CONSTRUCTION PLANS
FOR
**PONDEROSA AT
LORSON RANCH FILING NO. 3**
STREET/STORM SEWER AND UTILITY CONSTRUCTION PLANS

PUDSP-19-010

POND A3

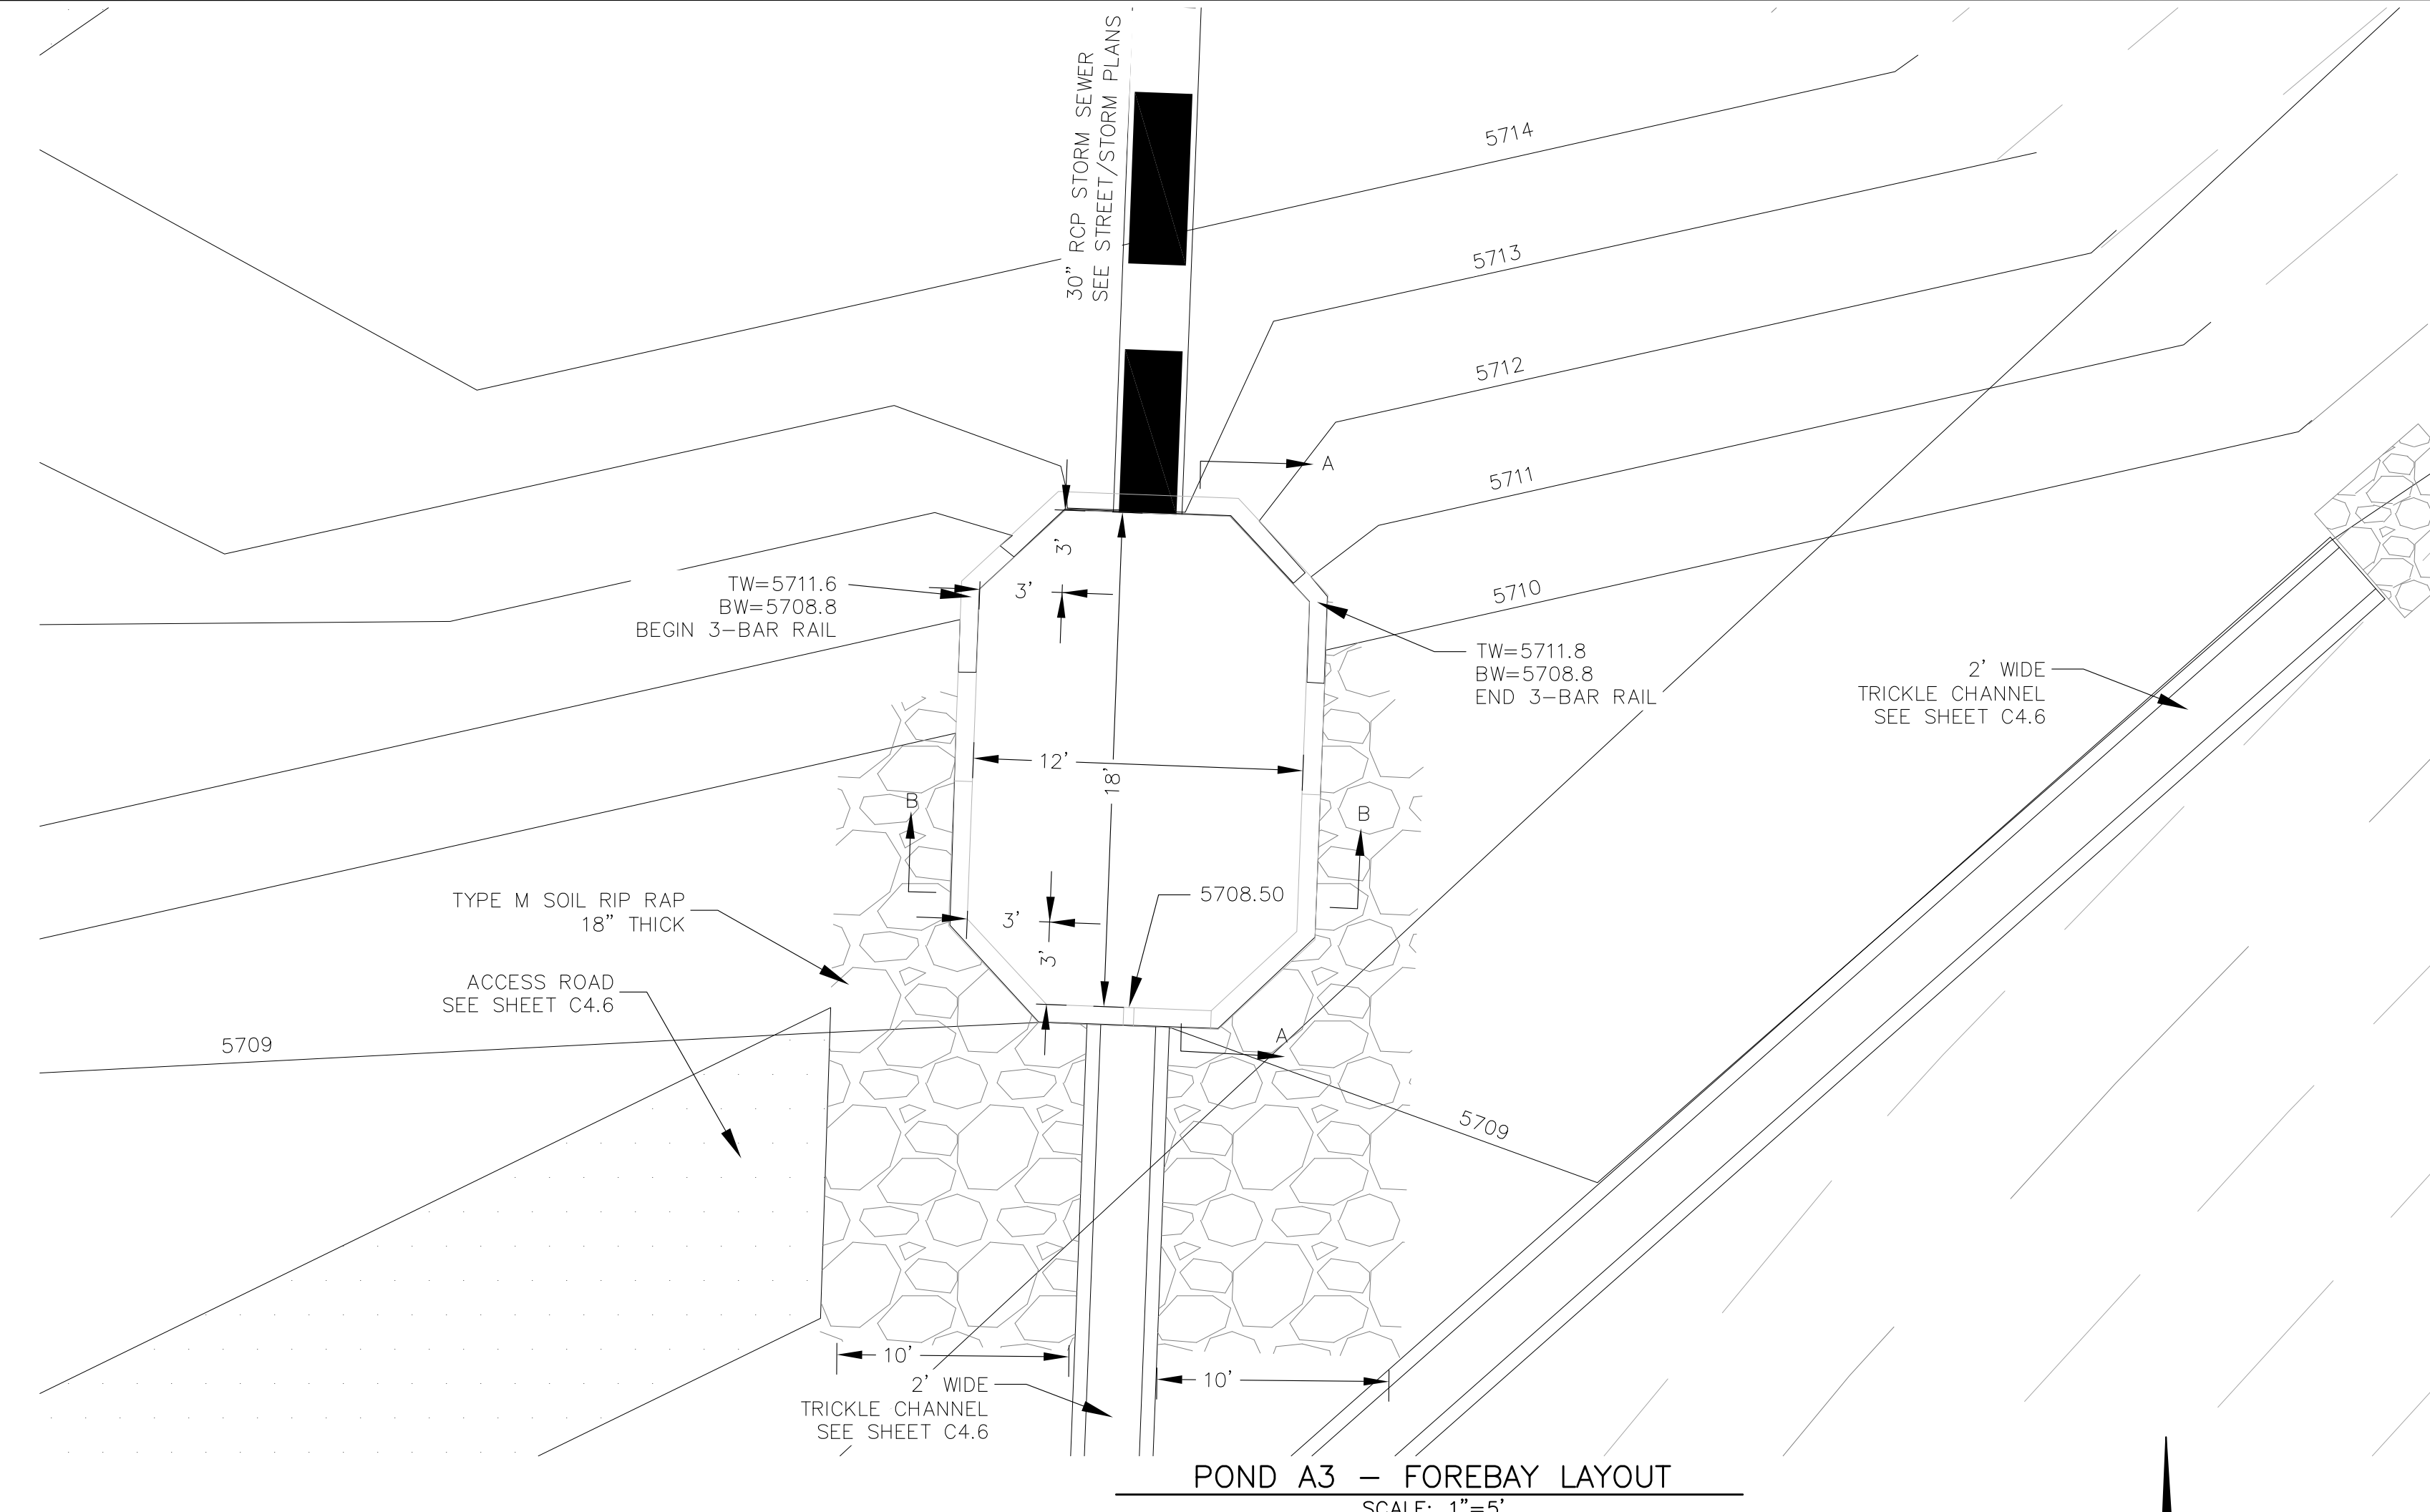
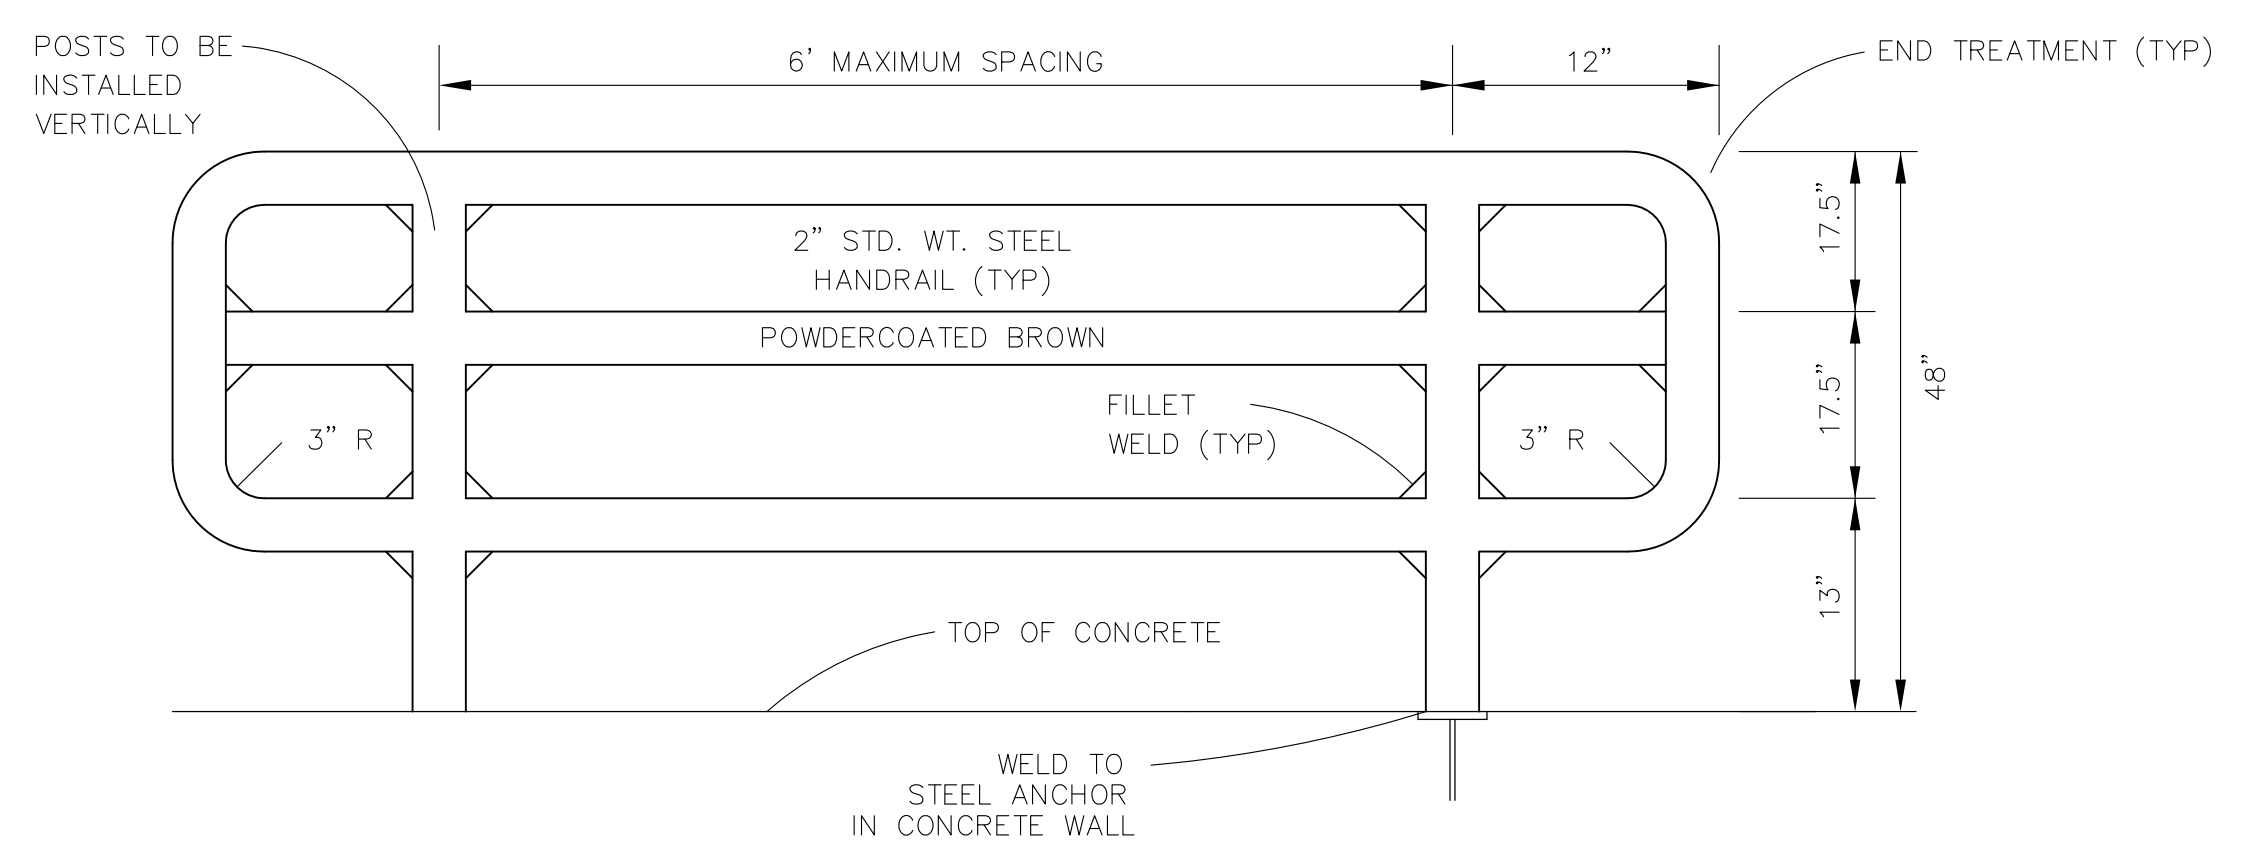
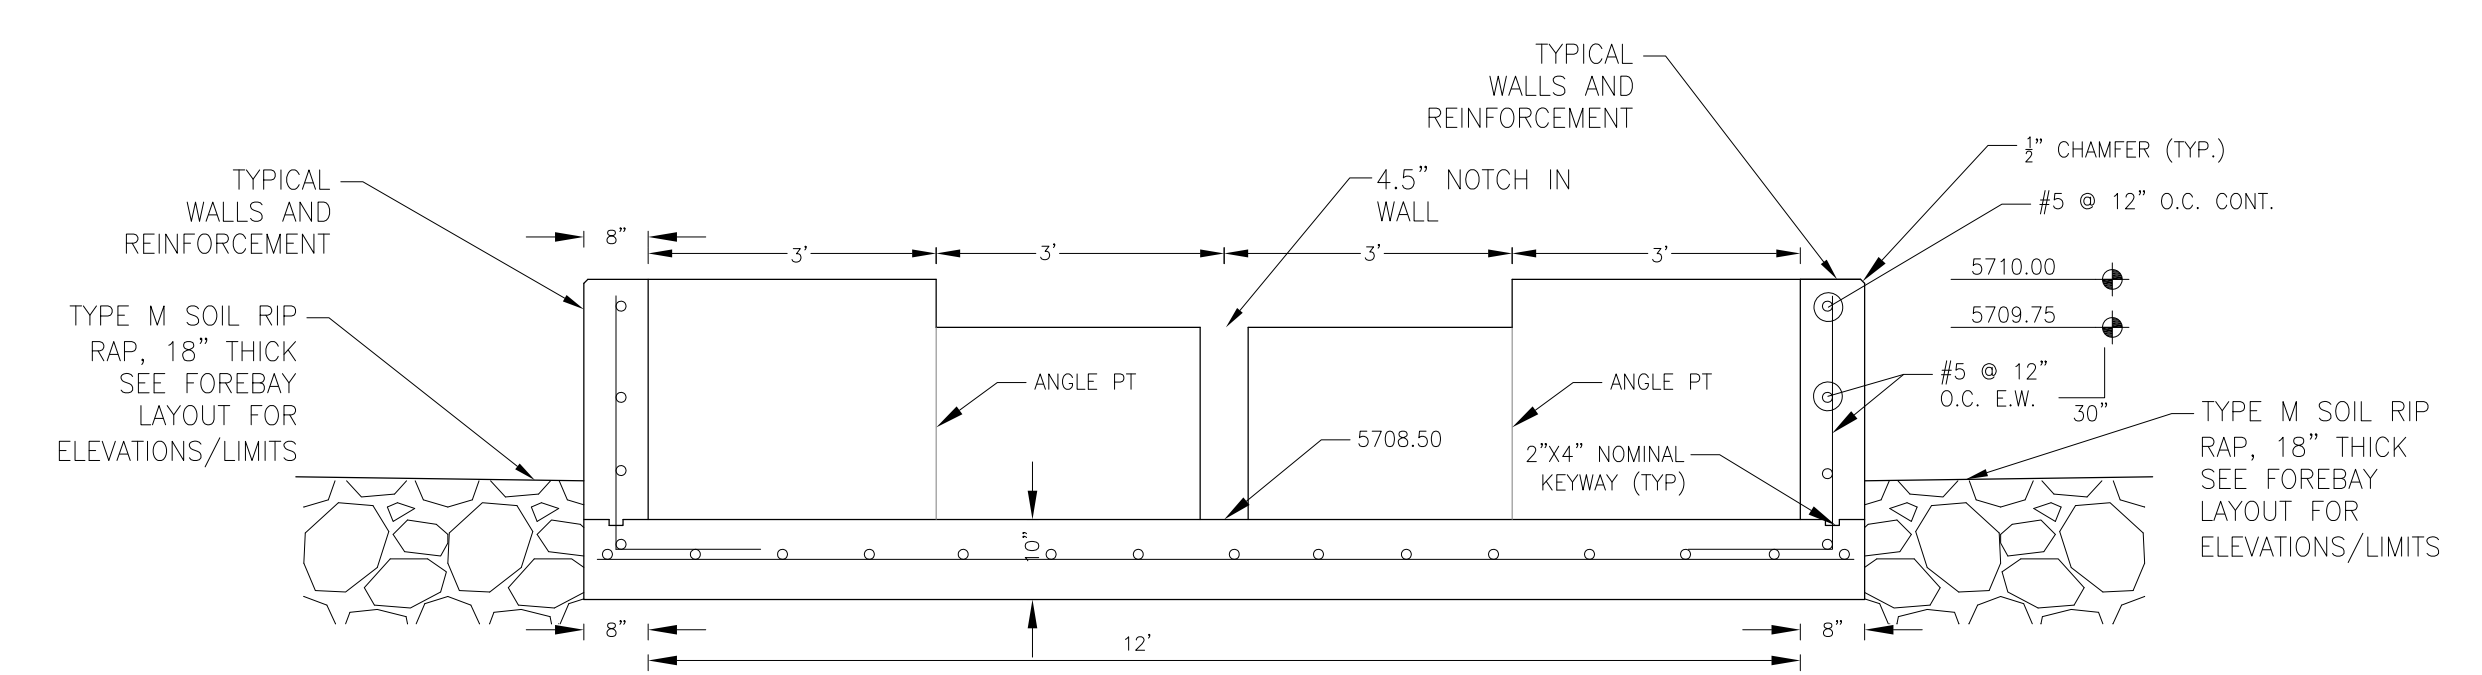
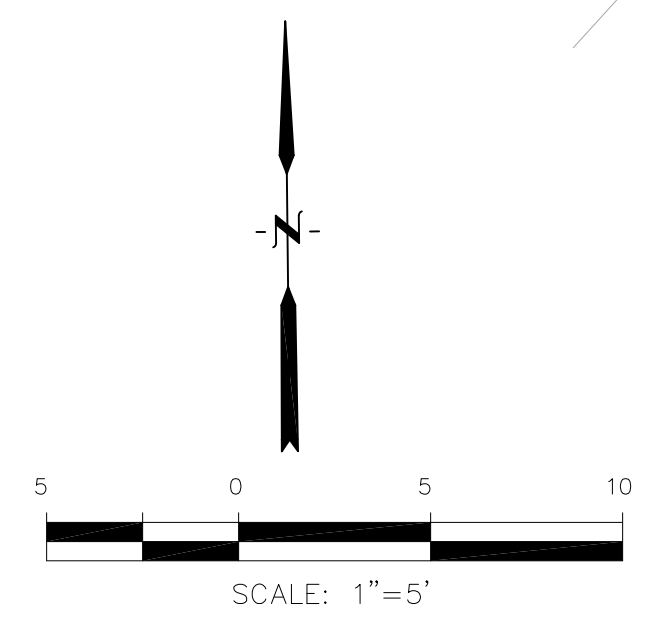
Duplicate sheet from the GEC.
See GEC Plan for redline comments.
Remove all duplicate sheets.
